Application for a non-material amendment following a grant of planning permission.

Number	48
Suffix	
Property name	
Address line 1	Angmering Lane
Address line 2	
Address line 3	
Town/city	East Preston
Postcode	BN16 2TA
Description of site location must be completed if postcode is not known:	
Easting (x)	506385
Northing (y)	101759
Description

Erection of a two storey rear extension. Existing brick house to be rendered in white with alterations to fenestration.

Reference number:	EP/128/20/HH
Date of decision	11/12/2020

Drawing No. 0010 Drawing Name: GA Proposed Elevations

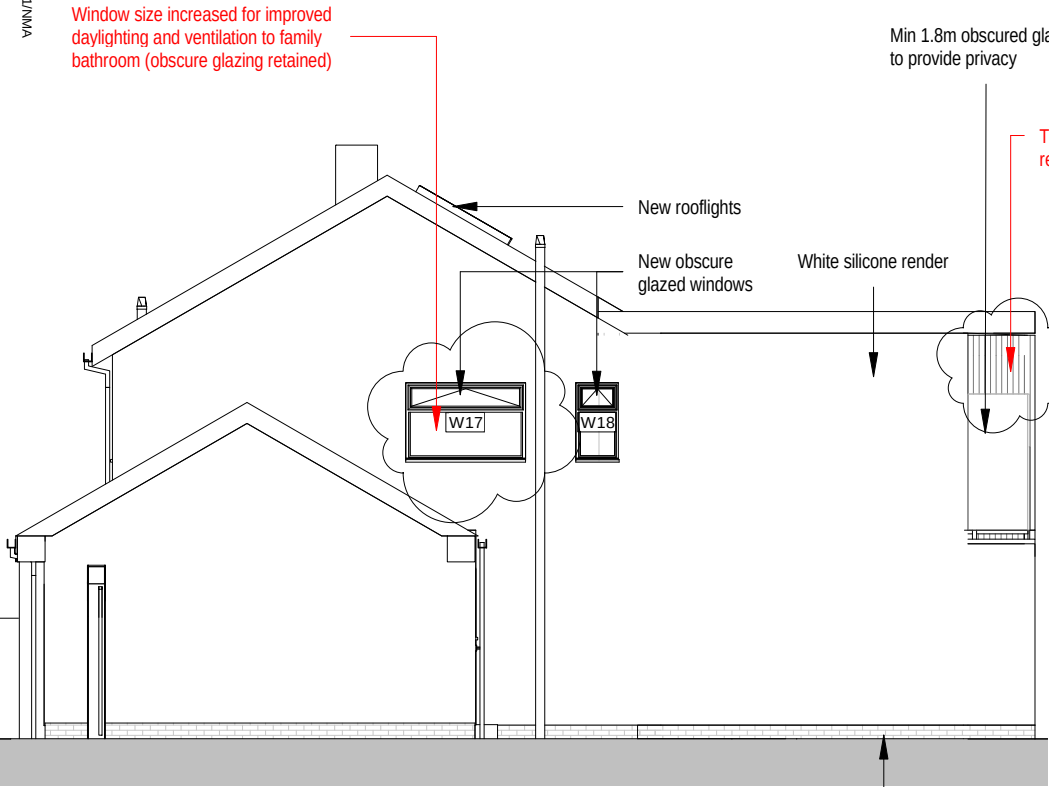
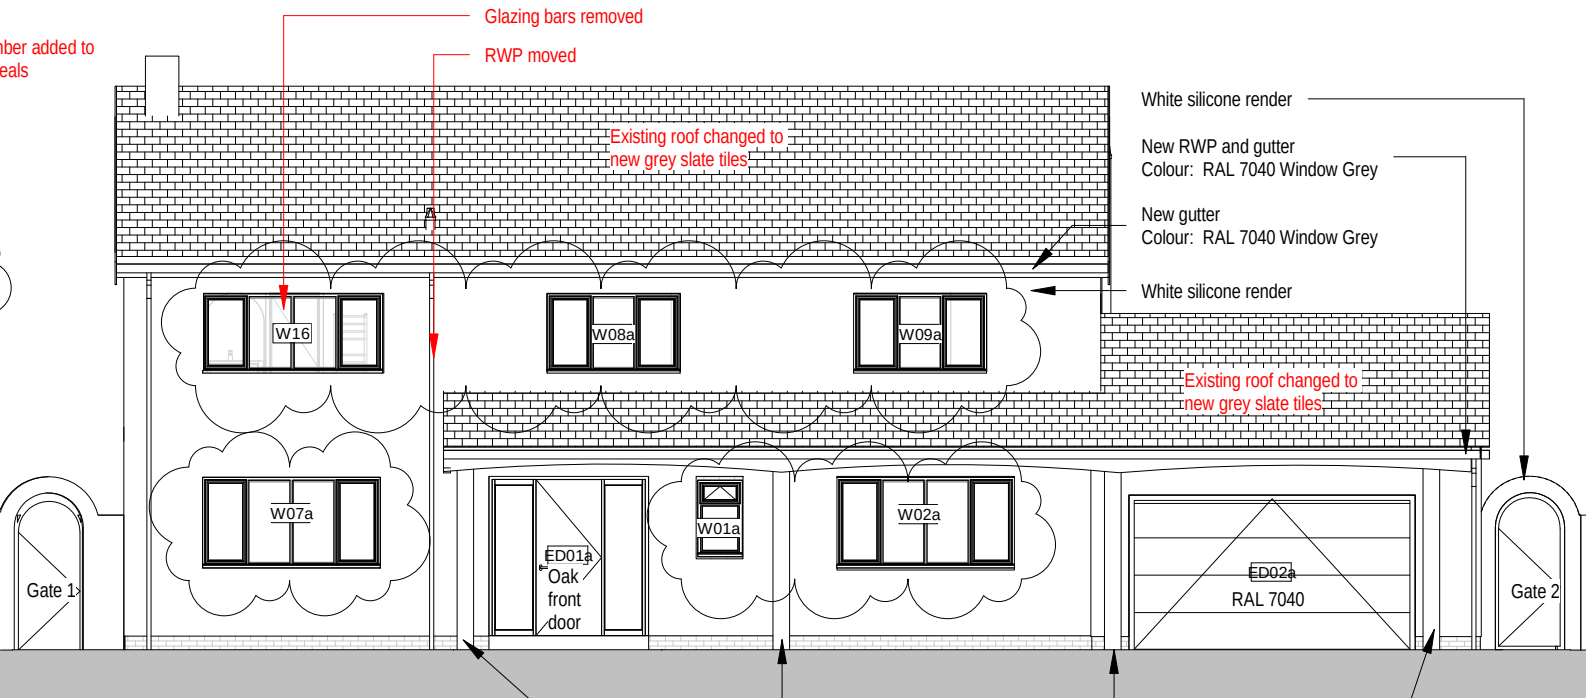
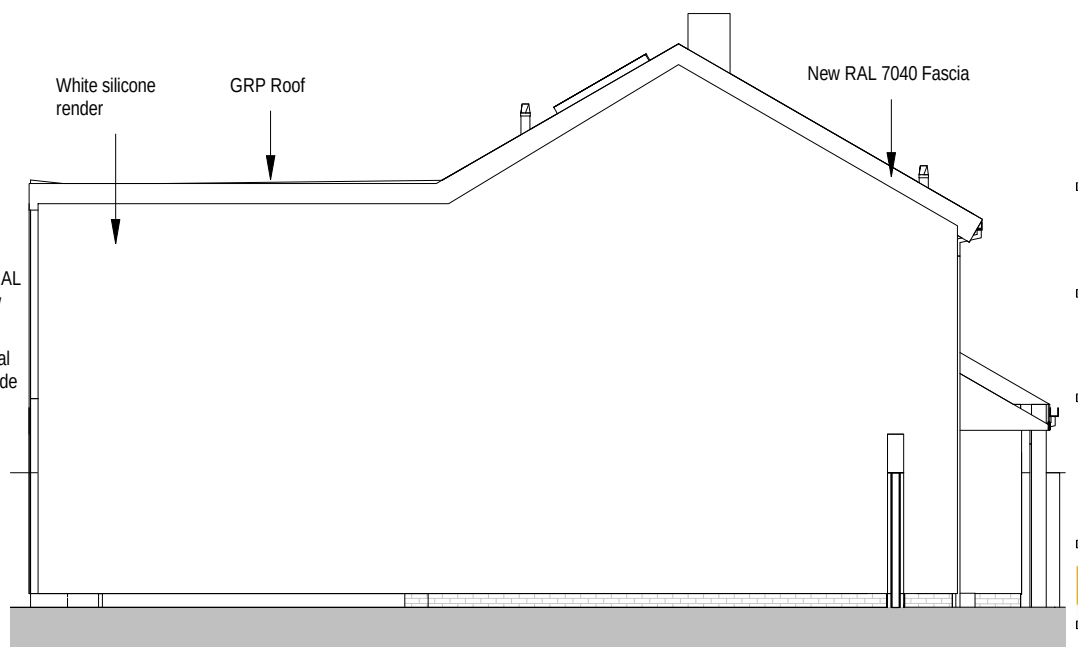
Re-roofing to existing house in grey slate tiles.
Rear windows (W19,W20 and W21) changed from 2 panes to 3.
ED09 changed from fixed window to bifolds.
Window size increased for improved daylighting and ventilation to family bathroom (obscure glazing retained).
Window frame RAL colour changed from 7037 'Dusty Grey' to 7040 'Window Grey'.
RWP position moved to avoid staining on new slate roof.
Glazing bars omitted from front windows.
Timber cladding added to reveals of extension overhang.
(amendments noted in red on updated drawing)
